Landscape General Arrangement Plan

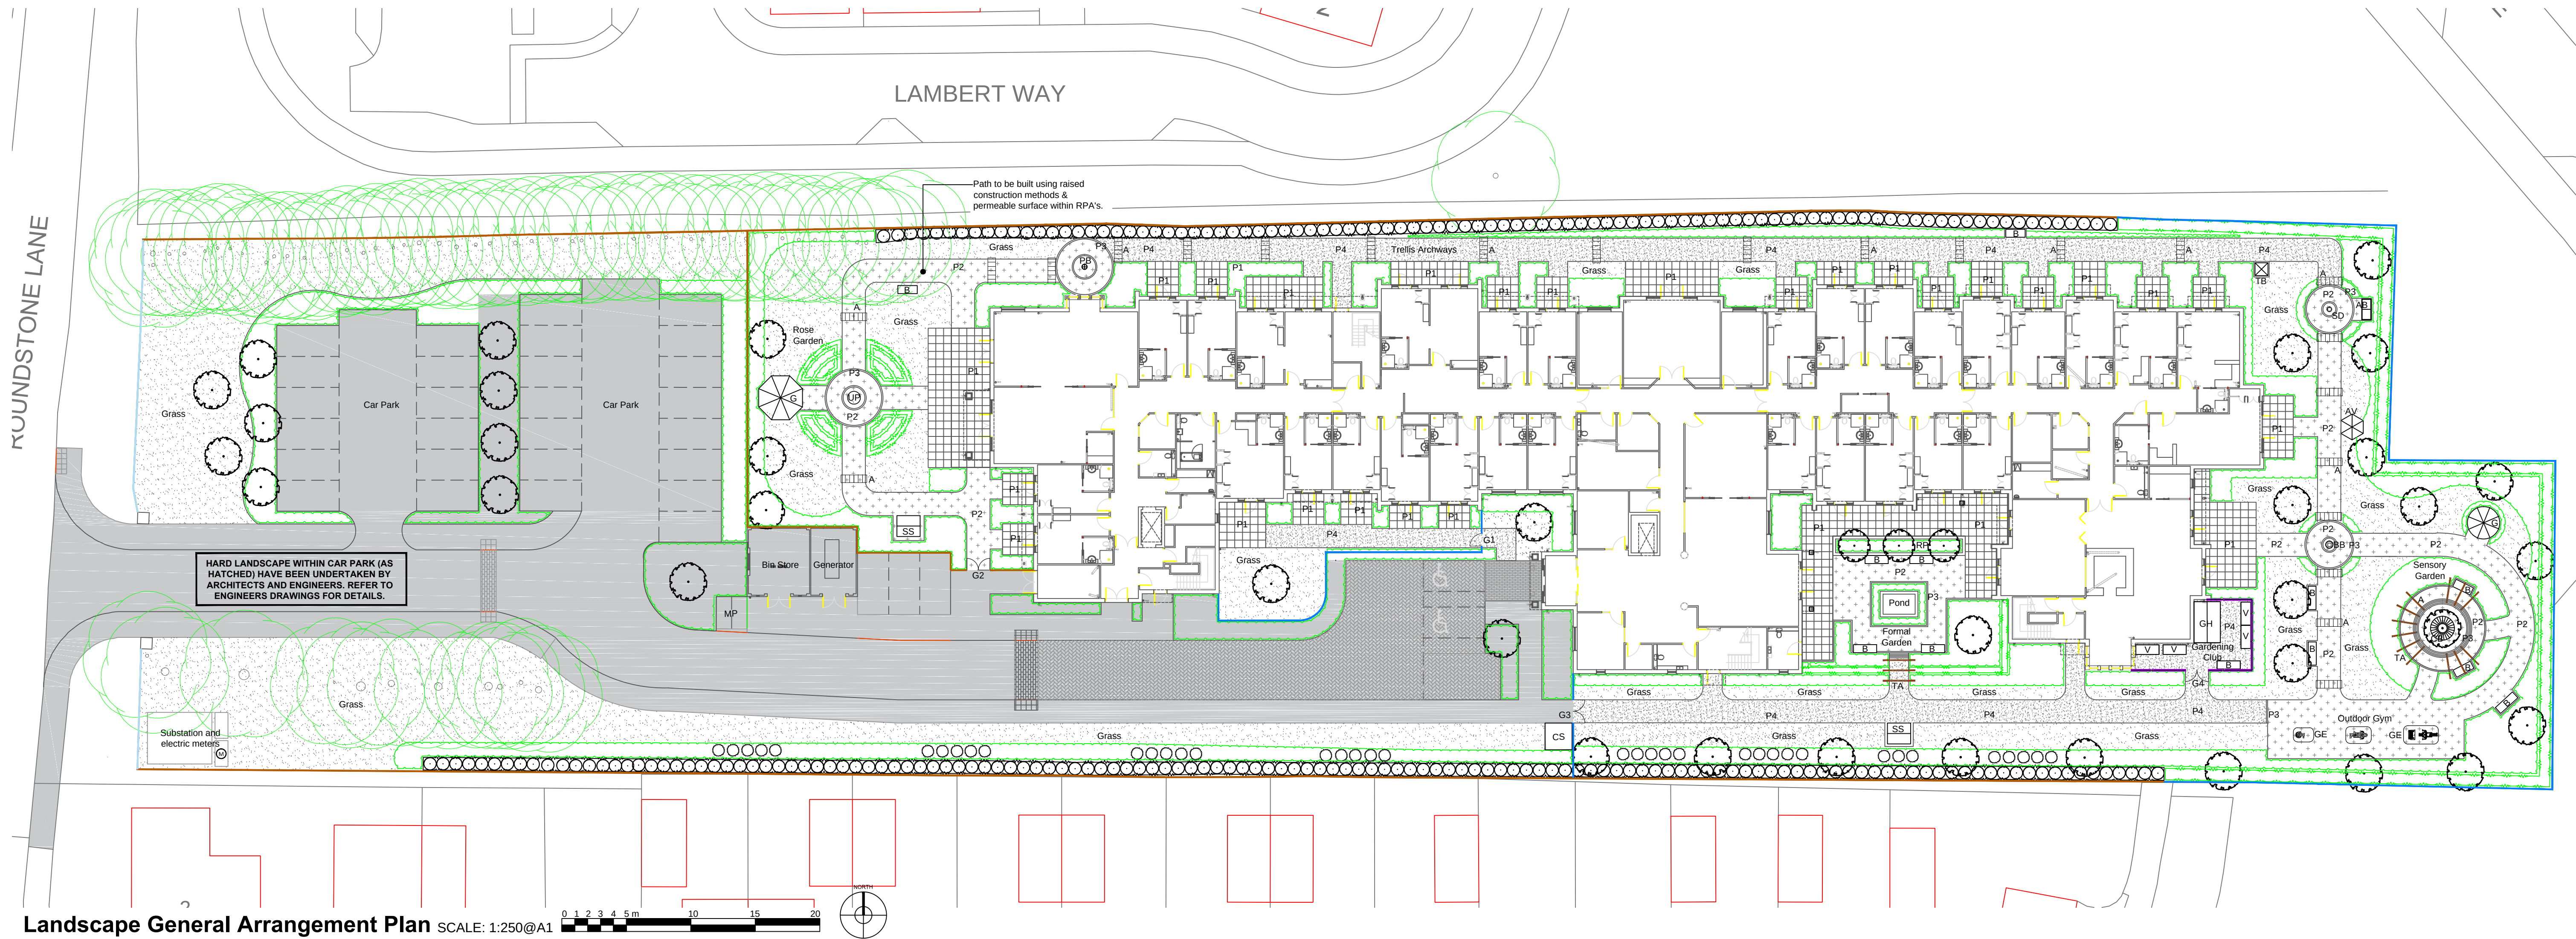
I have started to look at the above application in detail and notice that the drawing entitled Unit and Padmount Substation in a GRP Enclosure EDS-07-3102.01 rev C is incorrect. The Plan view of Site and Equipment refers to back edge of public footpath and the shape of the structure does not seem to accord with the block plan. Can you provide more precise layout details and clearly annotated elevations so that it is clear what elements of the structure are meter housing and generator and what will be visible from no2 adjoining the site and Roundstone Lane. I would also appreciate a street scene detailing the relationship and height of the structure in relation to the boundary with no 2 and proposed planting with a dimensioned distance from the boundary. Is there any opportunity to move the structure further from the site boundary to reduce the impact on the neighbouring property?

The site boundary elevation, boundary plan and general arrangement plan have a 300mm trellis to the top of the 1800mm timber fence as requested by the owners of the adjoining houses. The elevation does not show any planting as there is none proposed between the substation and the fence.
